KITTITAS COUNTY COMMUNITY DEVELOPMENT SERVICES

Subject: PD-16-00001 & LP-17-00004 Carrier Heights PUD & Preliminary Plat Additional Information Required

N 54°53'30" E
19.52'
SW CORNER
N 1/2 SW 1/4
PER BK 30
OF SURVEYS,
PG 12

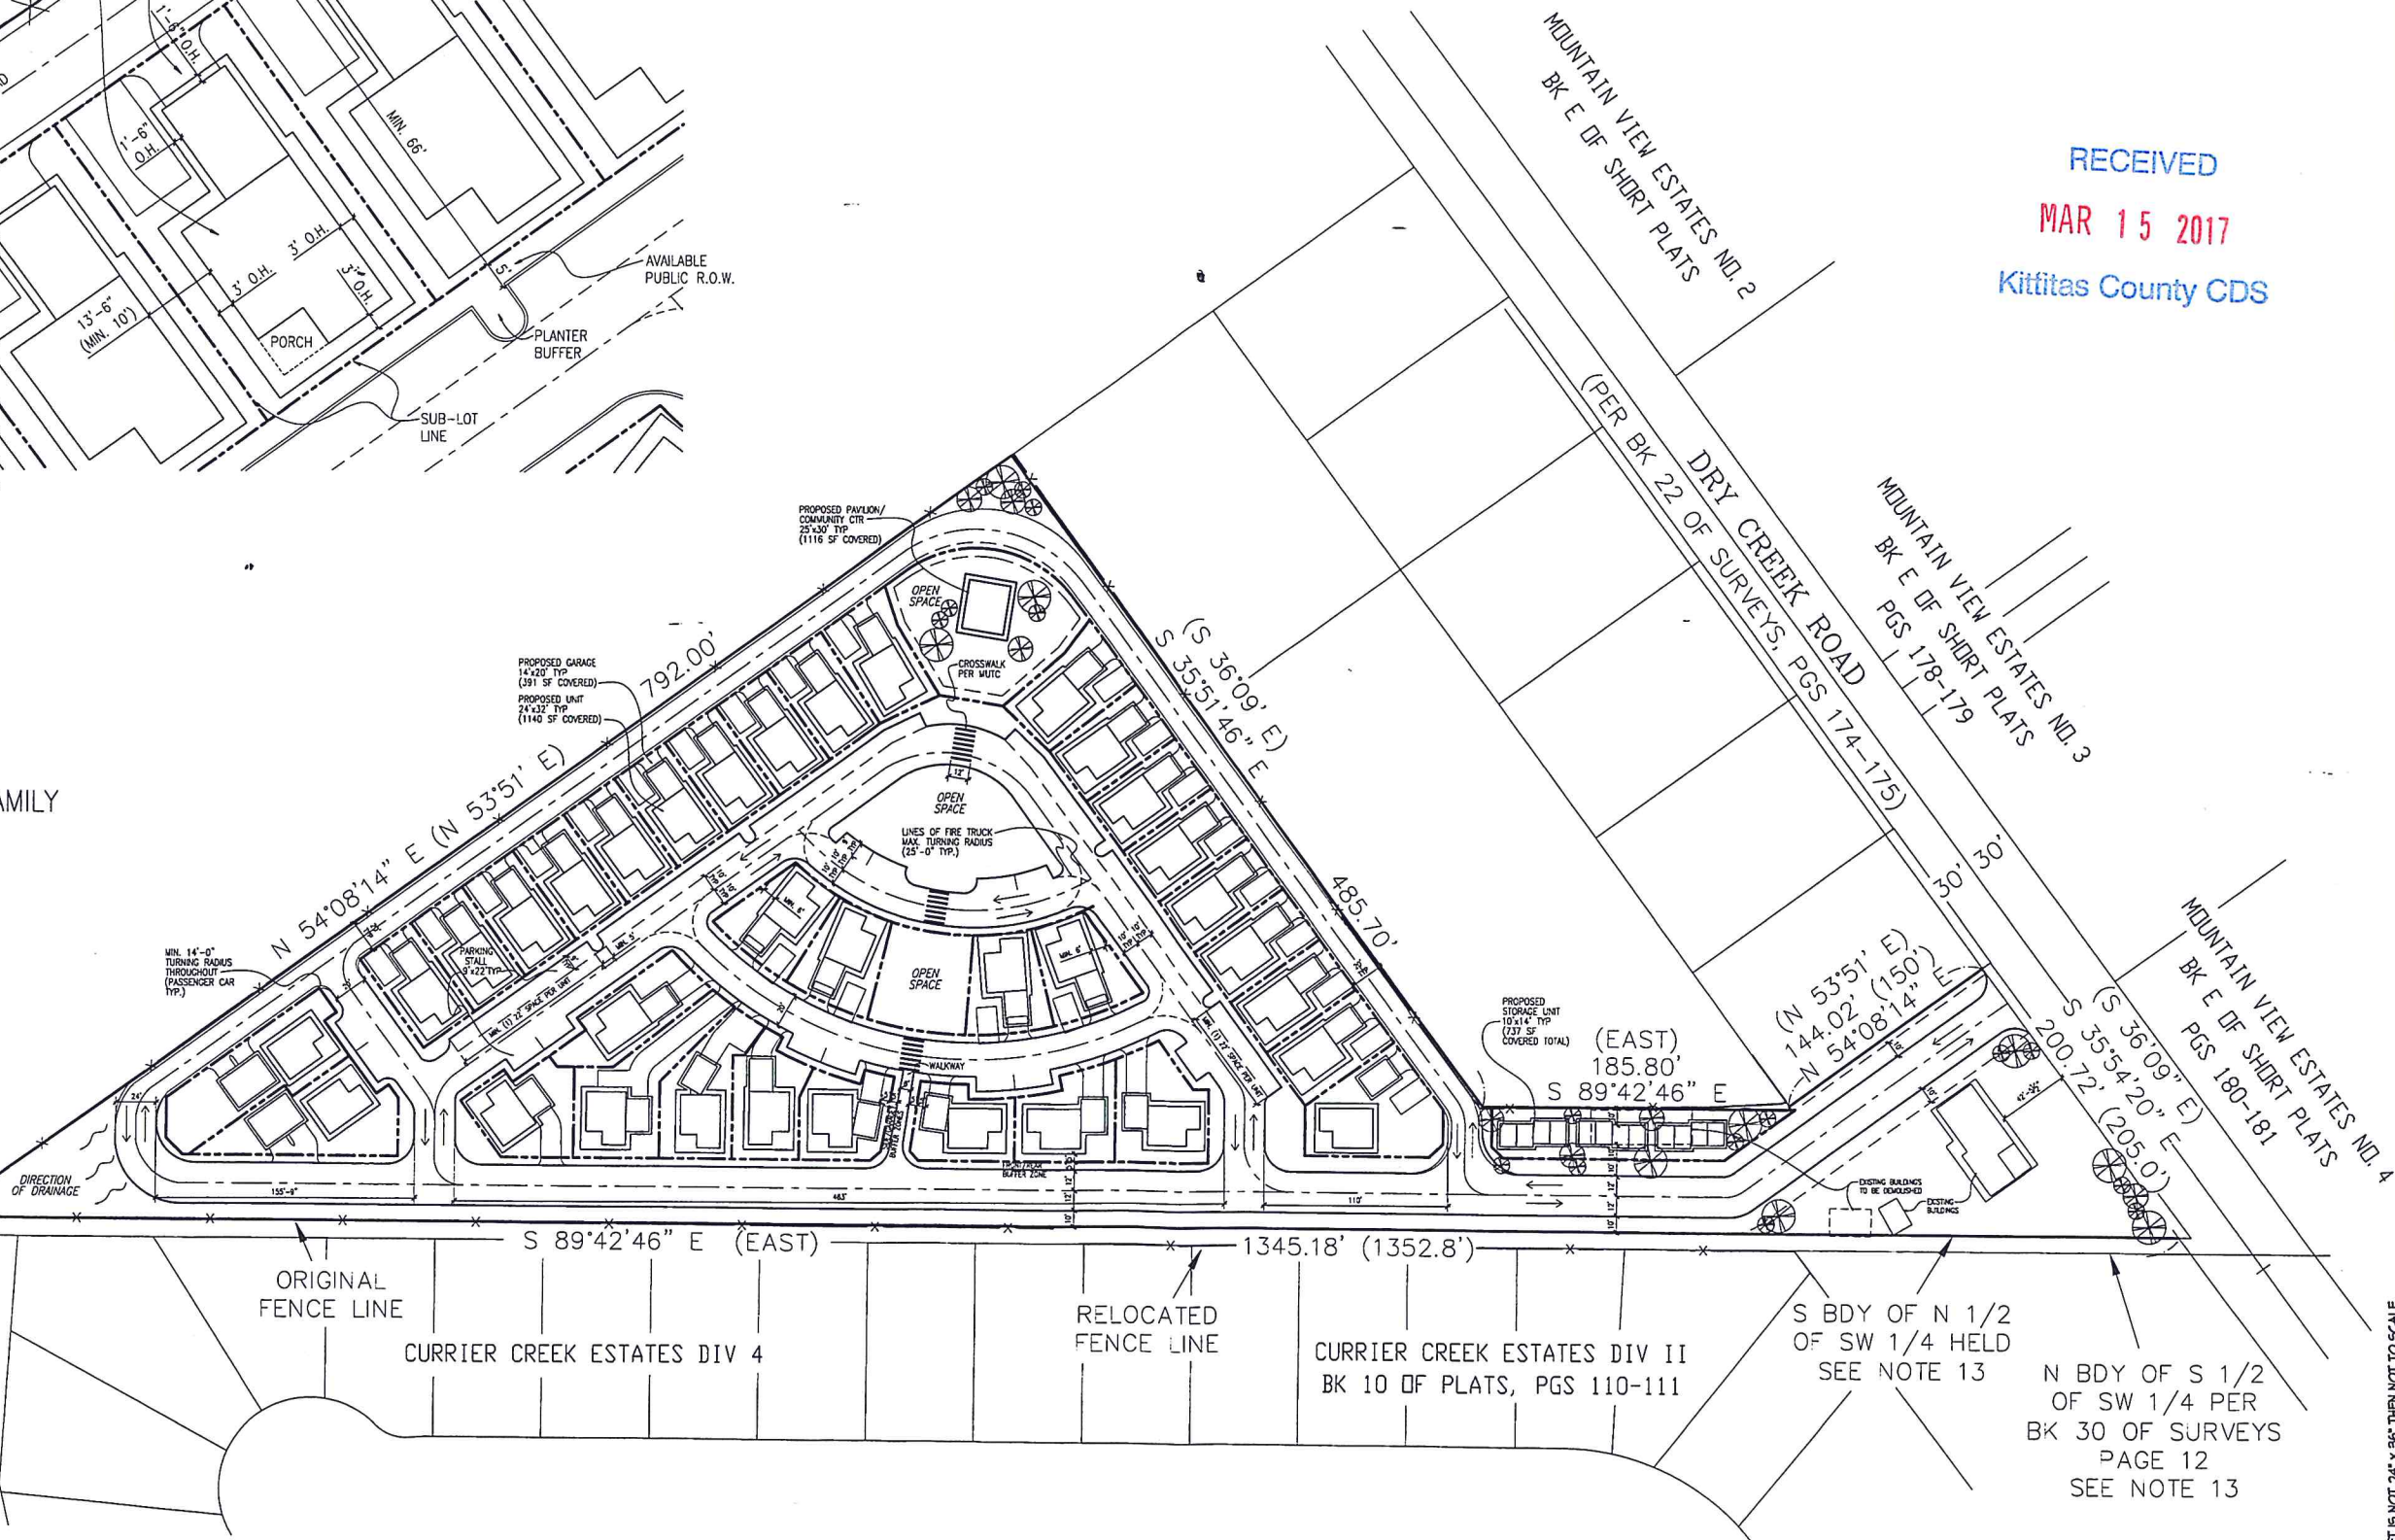
2. KCC 17.36.030 requires a preliminary development plan for the zone change application. KCC 16.12.020 requires preliminary plat drawings for the preliminary plat application. The preliminary development plan submitted with the PUD zone change application is not consistent with the preliminary plat drawings submitted with the preliminary plat application. Therefore, please submit consistent development plan and preliminary plat drawings.

3. KCC 17.36.030(4)(D) requires critical areas and natural features be shown on the preliminary development plan. According to the National Wetland Inventory, the site contains wetlands, which are not shown on the development plan. Please revise the preliminary development plan to show critical areas and natural features.

4. According to KCC 17.36.030(6), a phasing plan is required with identified timelines. The development plan shows phasing, but no explanation is provided. Therefore, please provide a phasing plan with required timelines.

10. KCC 16.12.030(3) requires the location of all existing ditches apparent or of record, marshes, areas subject to flooding, and direction of all watercourses to be shown on the preliminary plat. Therefore, please submit a revised preliminary plat that includes this information.

11. According to KCC 16.12.030(6), the total acreage and total number of lots within the proposed subdivision shall be indicated on sheet one of the plat. Please submit a revised preliminary plat that includes total acreage and total number of lots.

**PART OF SECTION 27, T. 18 N., R. 18 E., W.M.
KITITAS COUNTY, WASHINGTON**

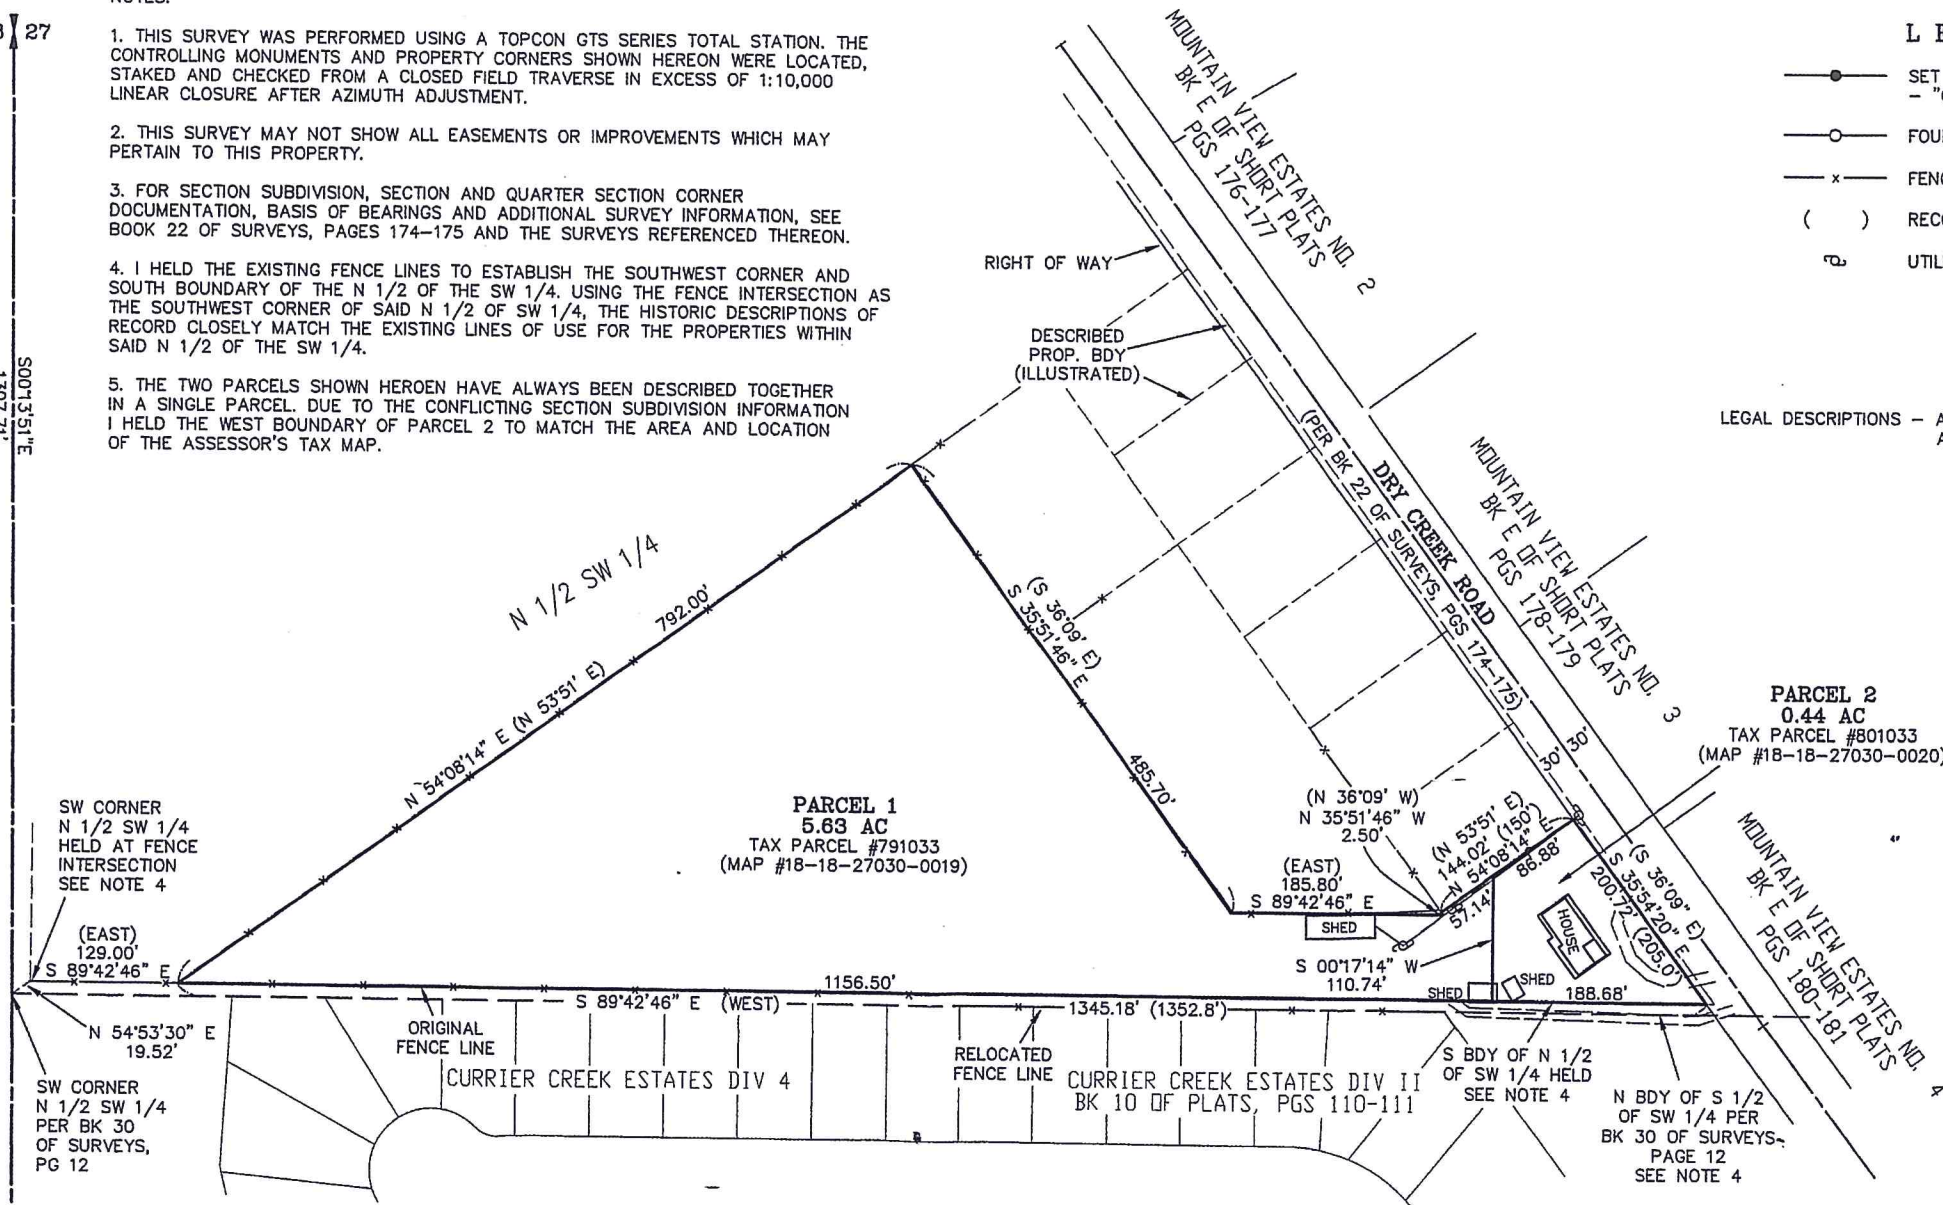
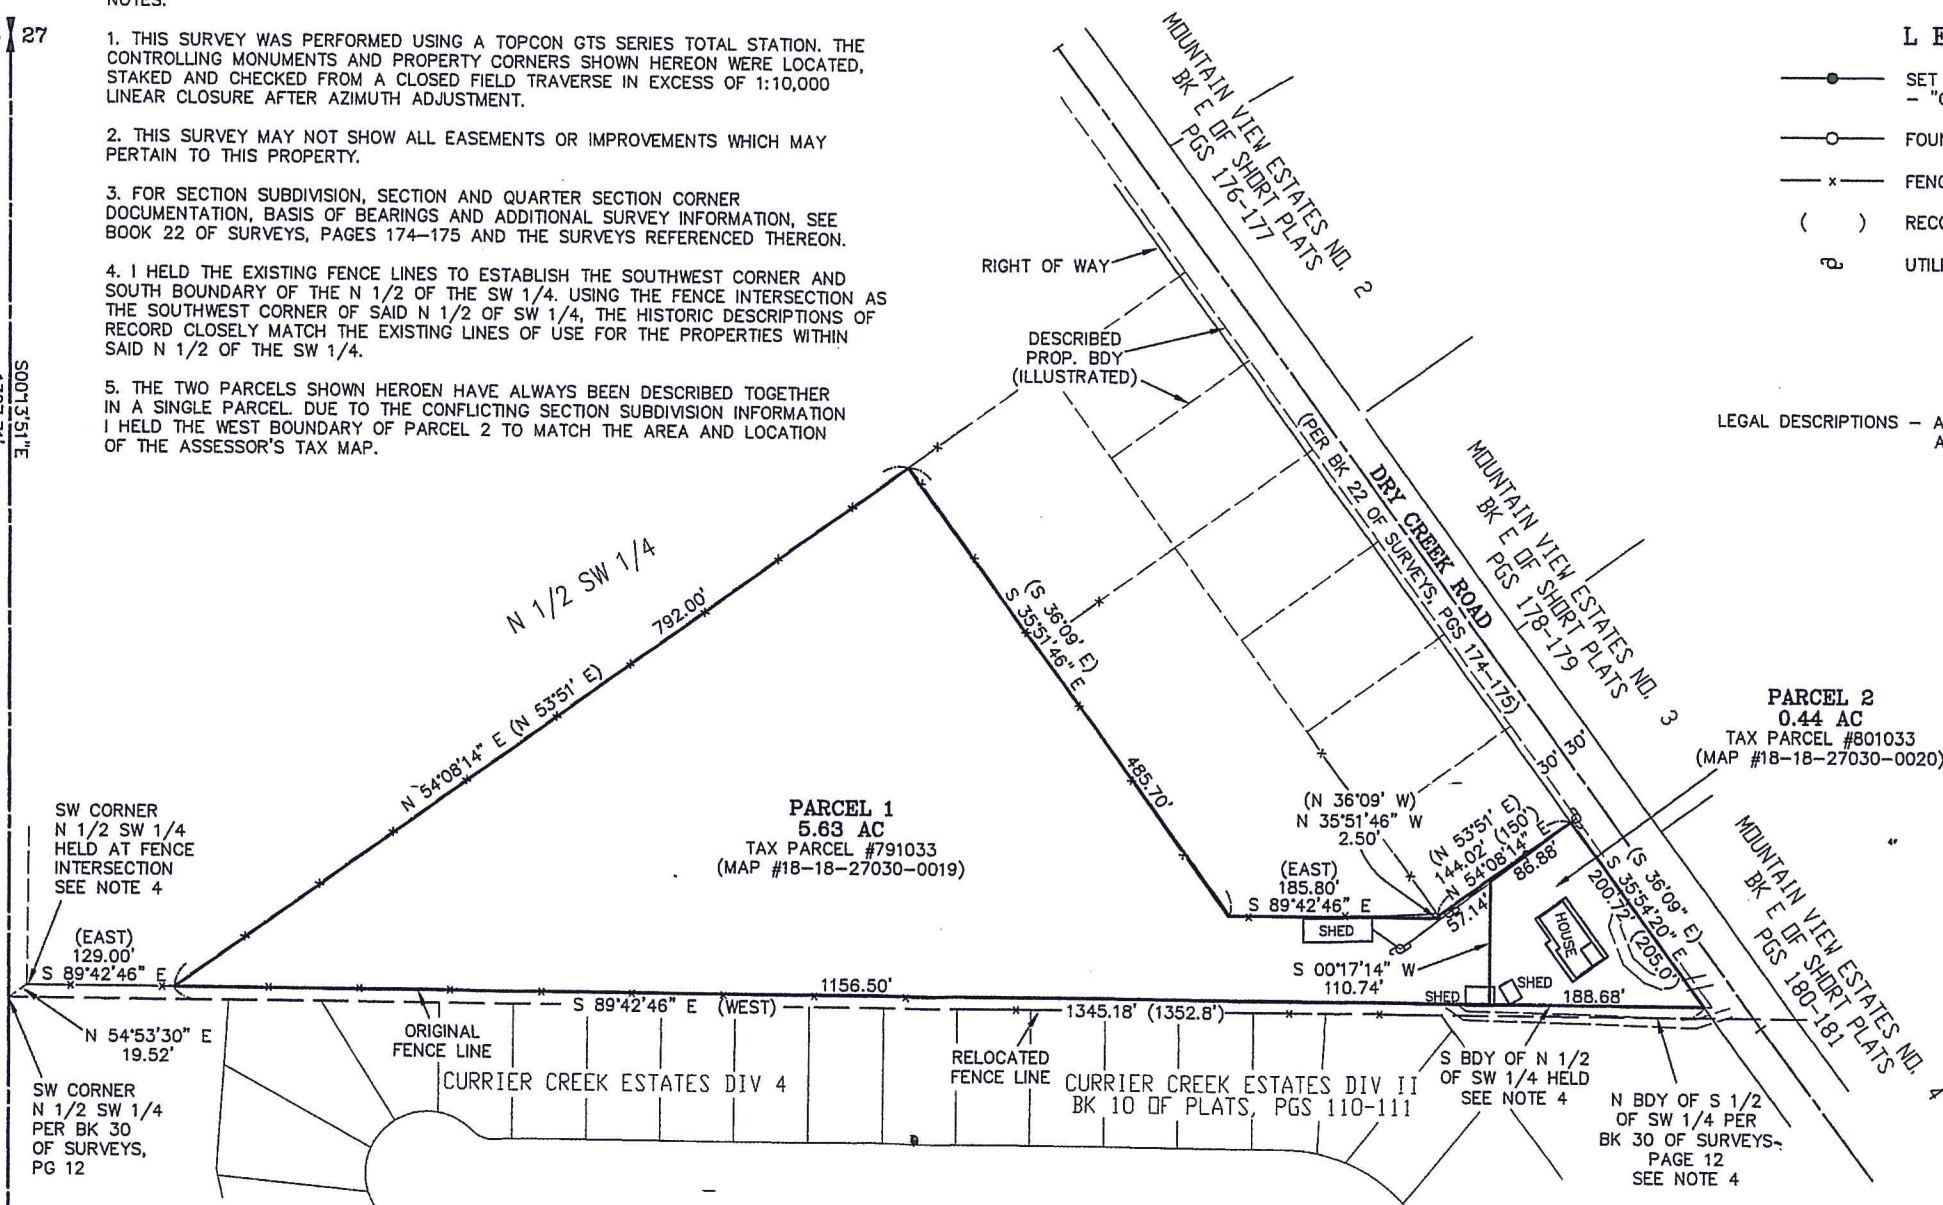
4.47 acres, which would not allow the proposed density without transfer of development rights. The plat application states that the total area of the property is 5.63 acres. Therefore, please revise the applications so that the correct acreage is shown, and describe how the proposal meets density requirements.
